RE: REVISED DRAINAGE PLAN FOR CAR QUEST AUTO PARTS STORE
(J-14/D55) RECEIVED NOVEMBER 5, 1986

On November 26, 1986, I conducted a field inspection of the Car Quest project site after receiving the revised drainage plan, dated November 5, 1986. During my inspection, I noted several items which appear to be contrary to the design of the approved plan.

GRADING AND DRAINAGE PLAN
 CAR QUEST AUTO PARTS STORE
 1321 SECOND STREET NW
 ALBUQUERQUE, NEW MEXICO

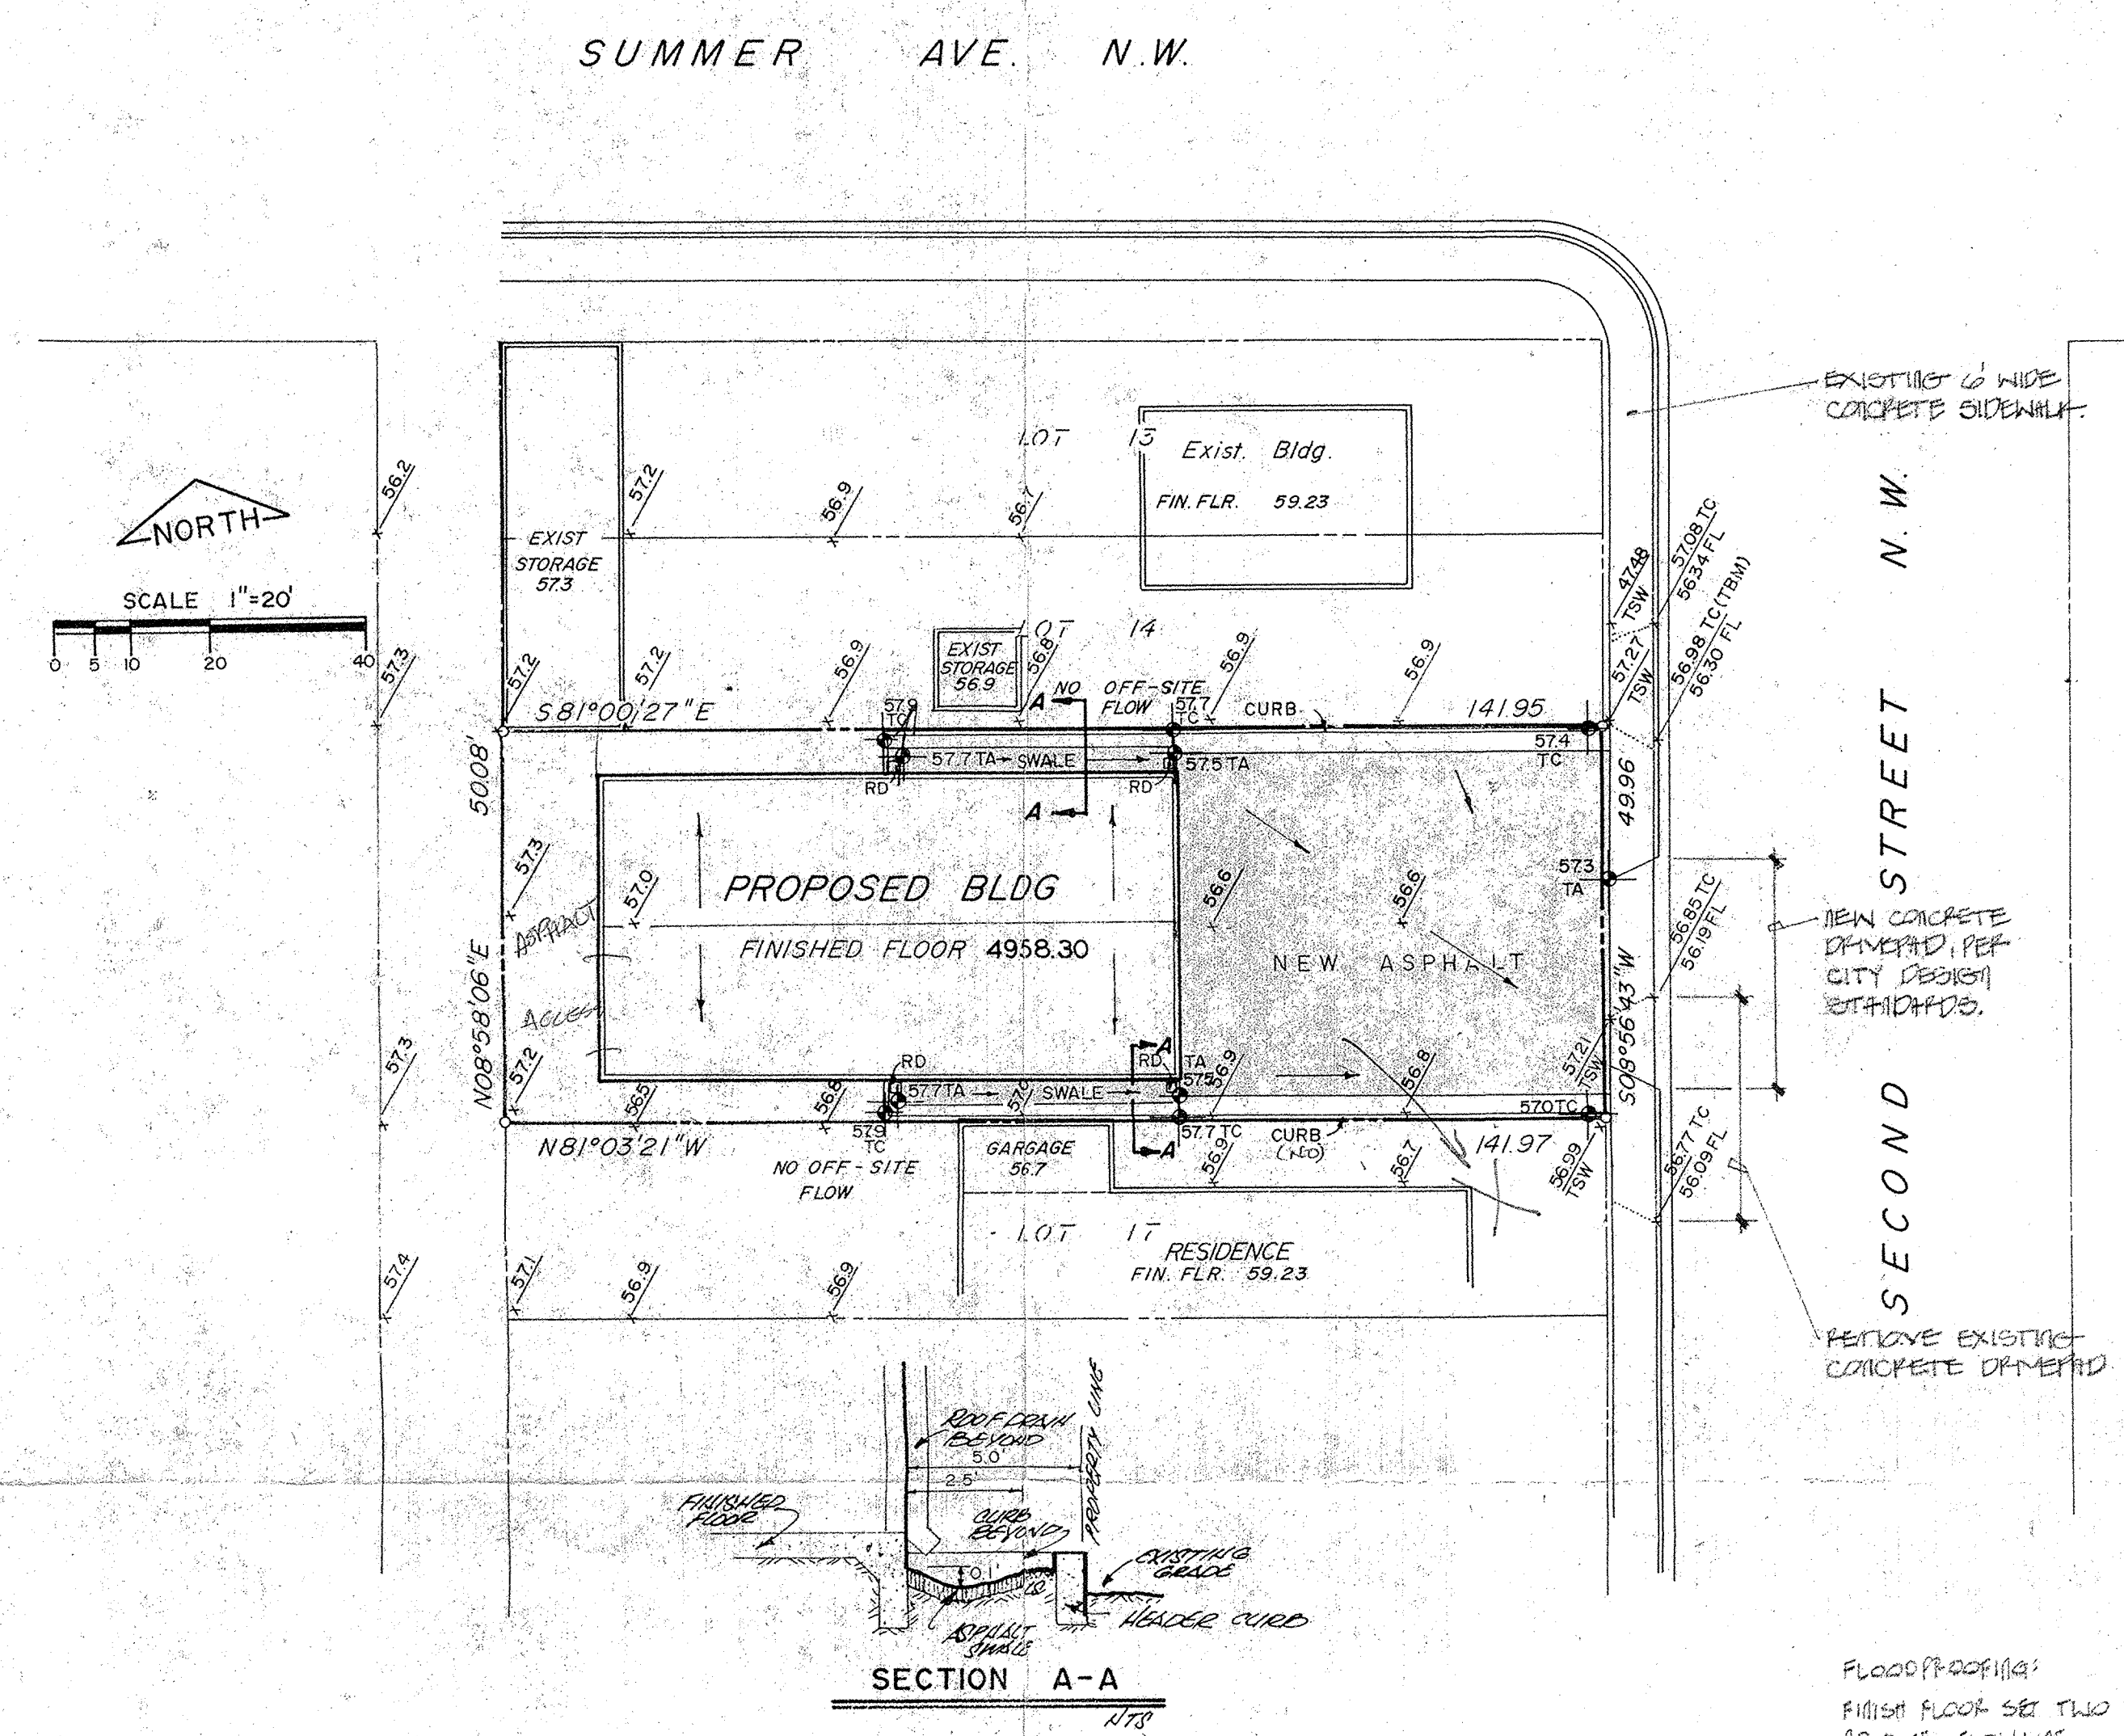
1. Drainage swale along the north side of the building is not containing roof drainage on-site.
2. Down spout extensions at north side of building is routing water onto adjacent property to north.
3. Down spout at south side of building is draining water onto adjacent property to south.

Prior to issuance of Certificate of Occupancy, these items must be corrected.
